NORTH FALLS OFFSHORE WIND FARM

Appendix B5 to the Natural England Deadline 5 Submission
Natural England's Marine Processes Advice on the Applicant's Deadline 4 Documents

Planning Inspectorate Reference EN010119

30 May 2025

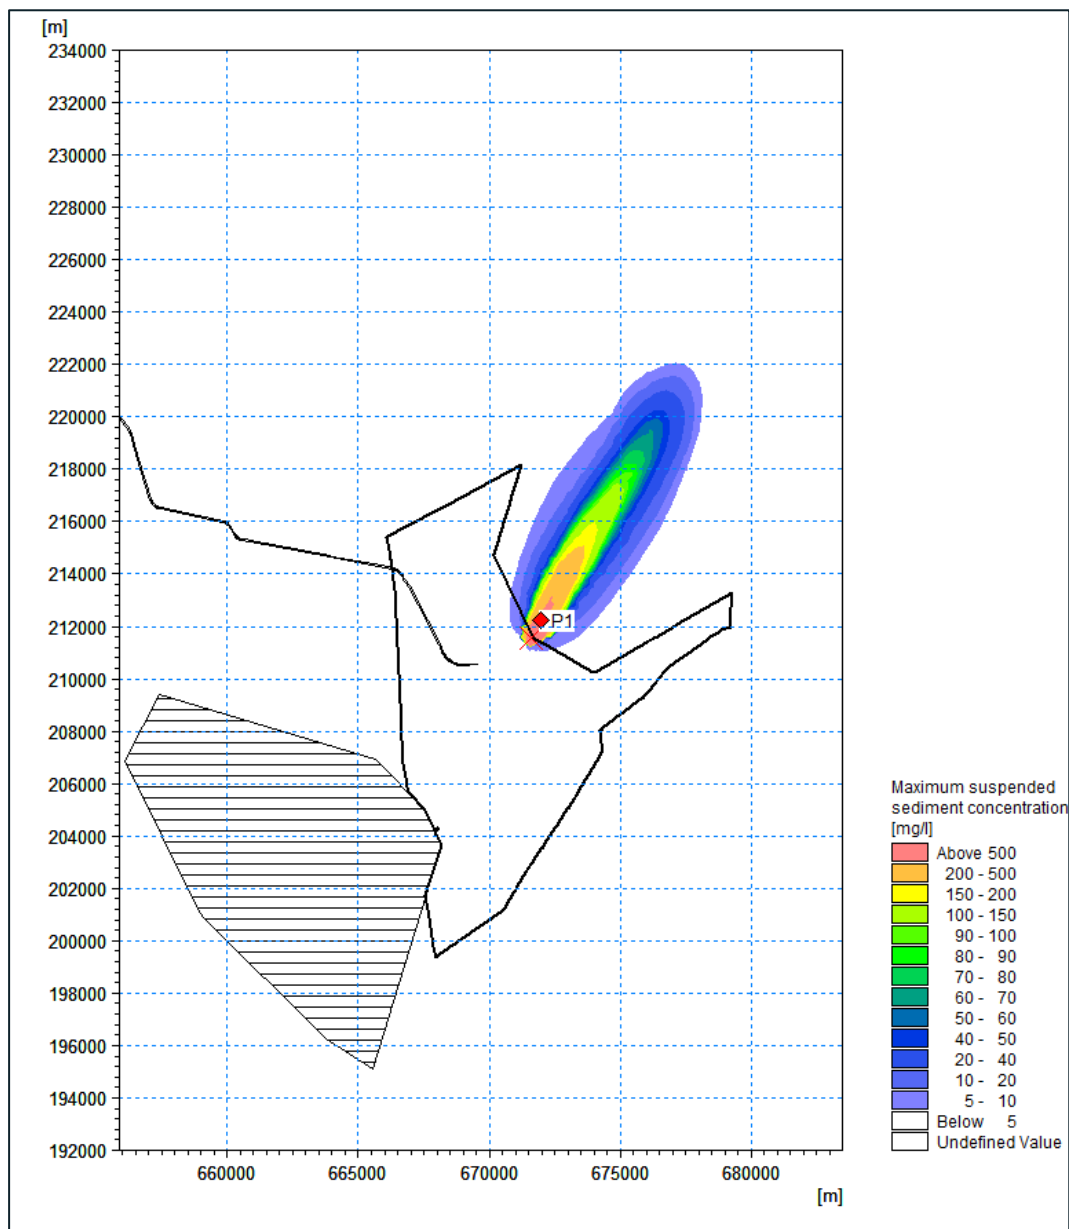
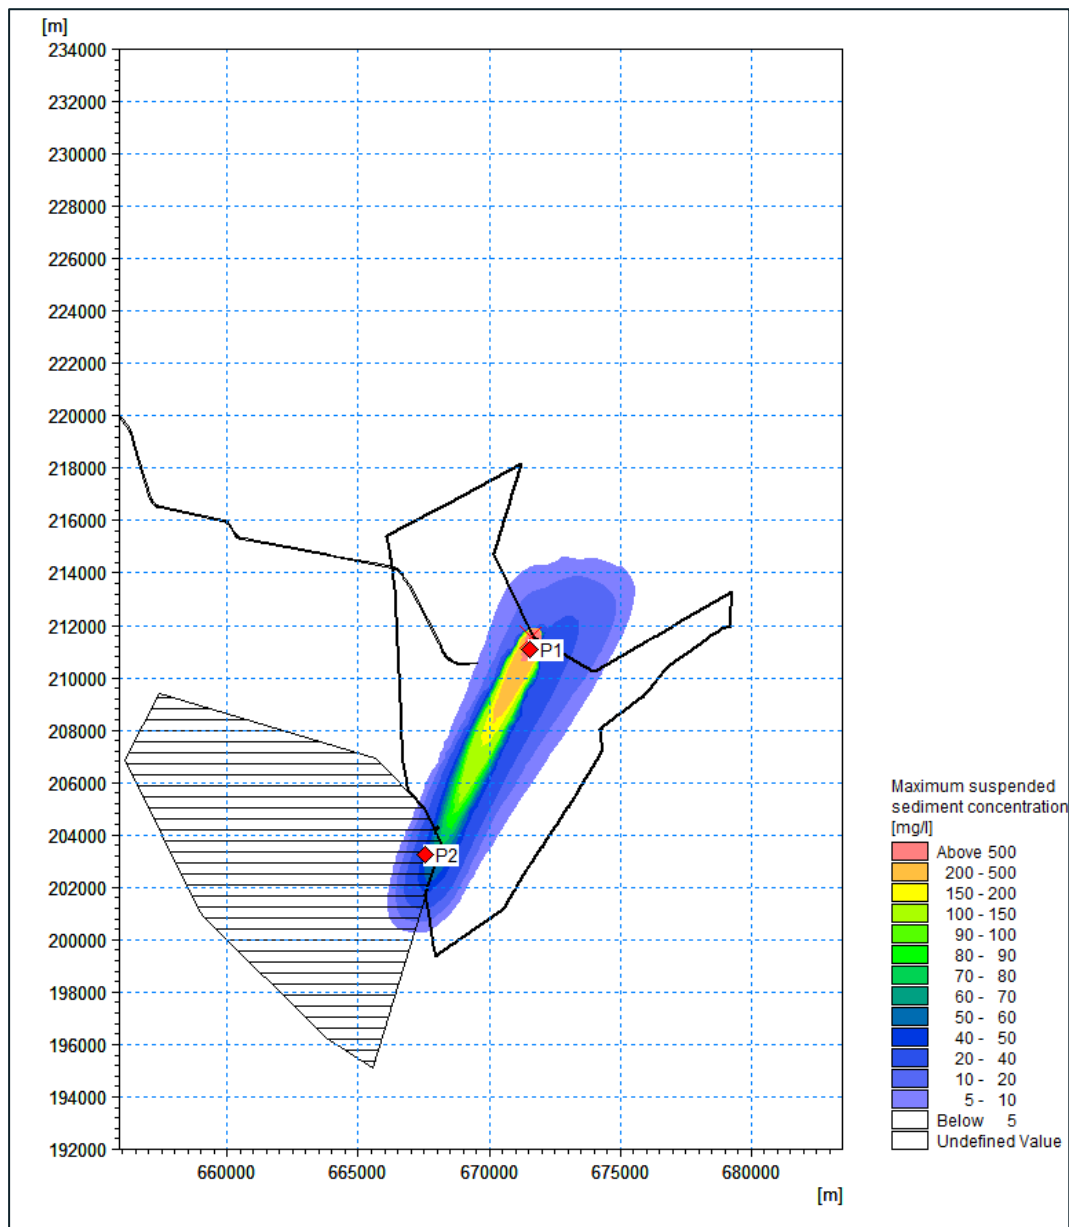
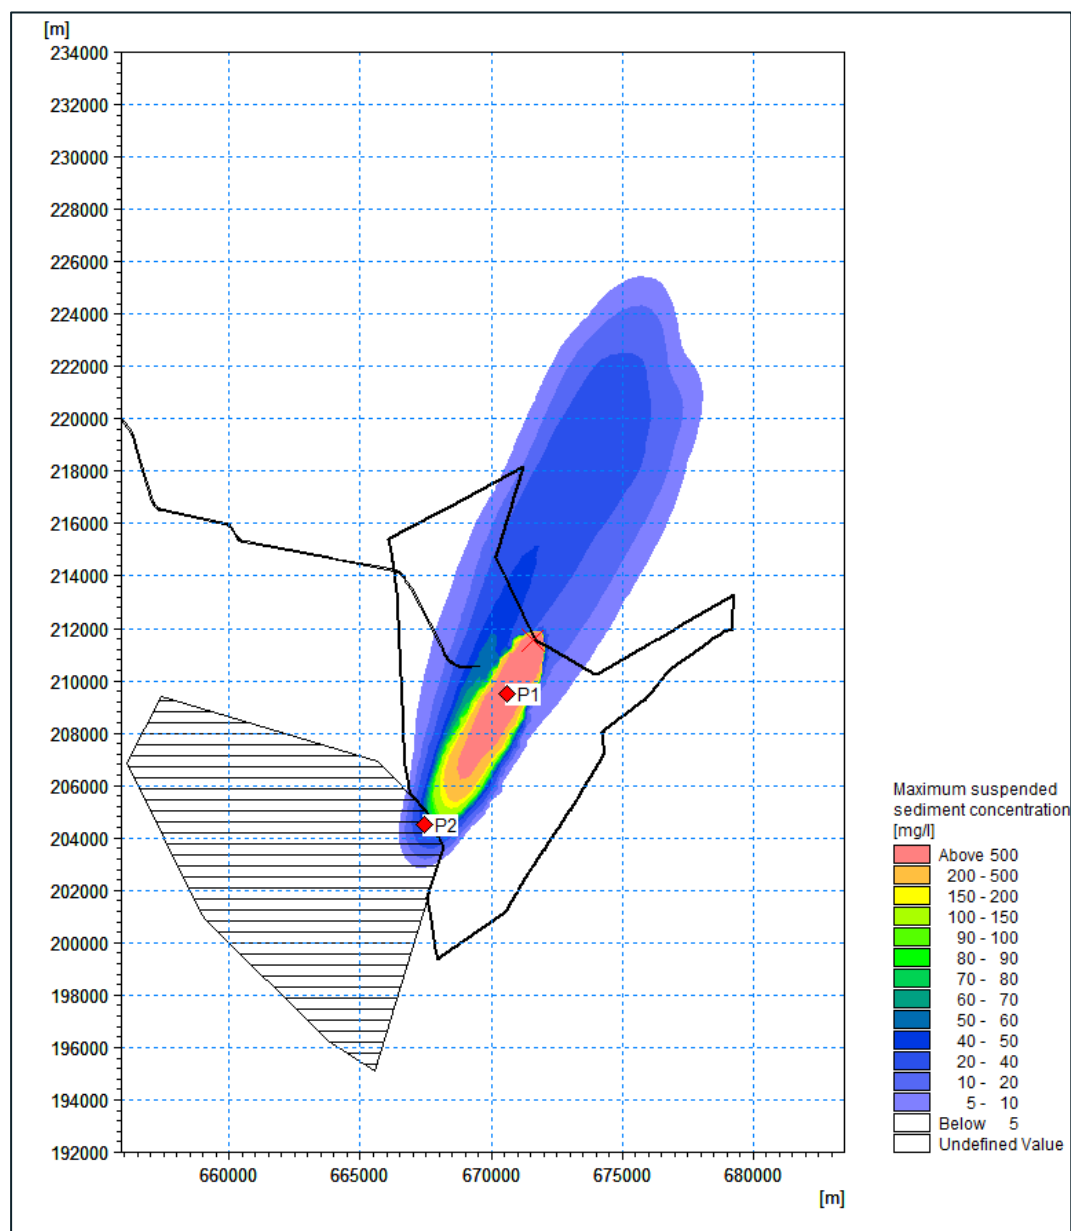
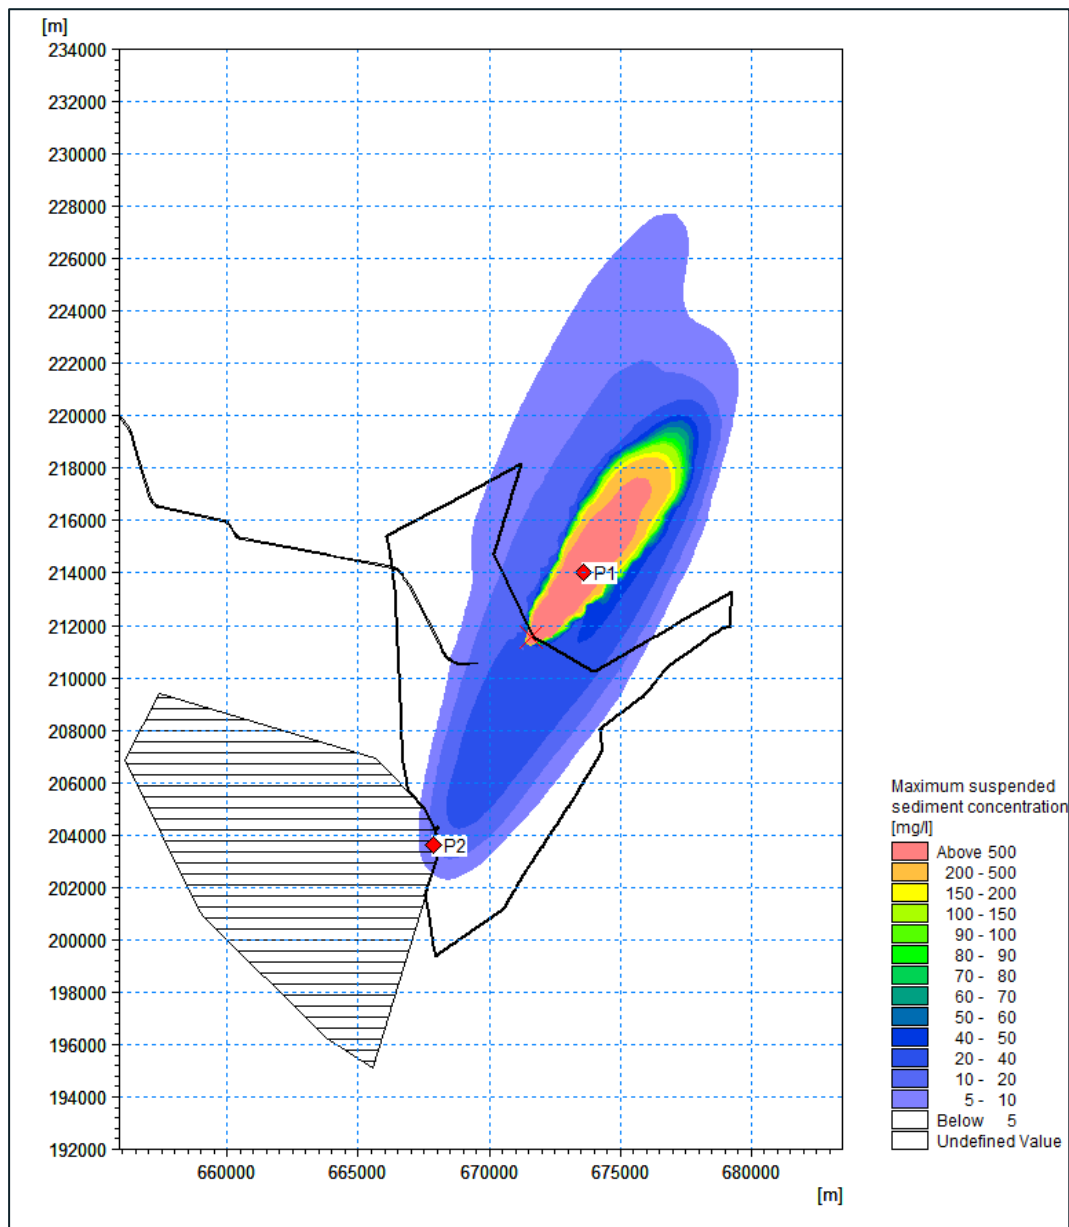
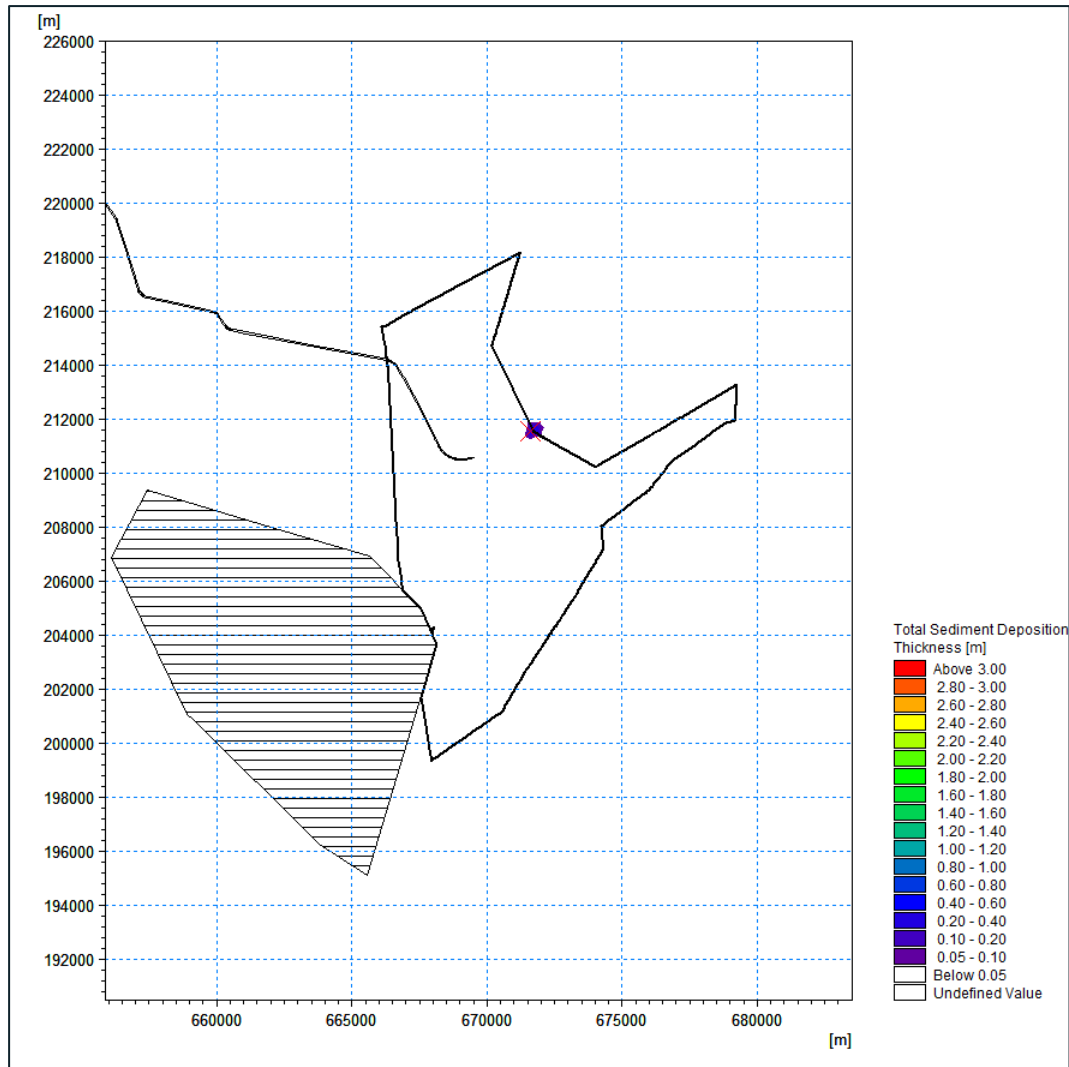
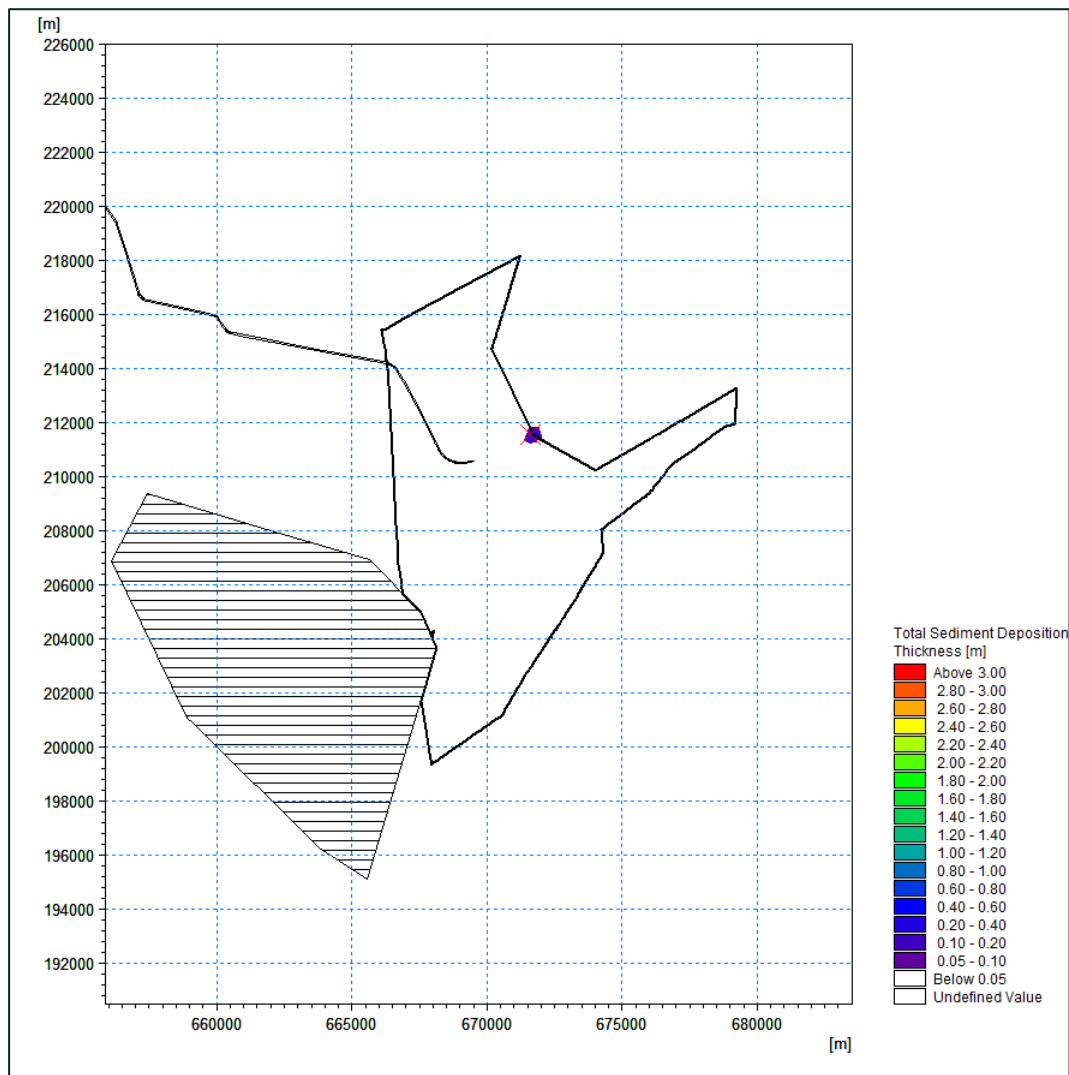
protection requirement adjacent to the SAC should be considered in the model.	
5	6.15	<p>Natural England notes that the model setup for sediment disposal within the array has used a worst-case location for sediment dispersal at the northern end of the array. This shows that sediment deposition following sediment disposal within the array may extend up to 750m with a thickness of up to 0.5m. Given that there is the potential for sediment disposal to take place anywhere within the array, we advise that model output should be provided for sediment disposal adjacent to the MCZ.</p> <p>We also note that the modelling has not considered sediment dispersion near MLS SAC due to sediment disposal within the ECC disposal site. Therefore, the WCS for plume dispersion and associated sediment deposition due to disposal in the ECC needs to be clarified with respect to impacts on MLS SAC.</p>	<p>We advise that model output should be provided for a sediment disposal location adjacent to KKE MCZ, to inform understanding of the potential impacts to seabed level change at the MCZ due to sediment disposal.</p> <p>We also advise that the WCS for sediment disposal in the ECC with respect to MLS SAC, should be considered in the assessment.</p>
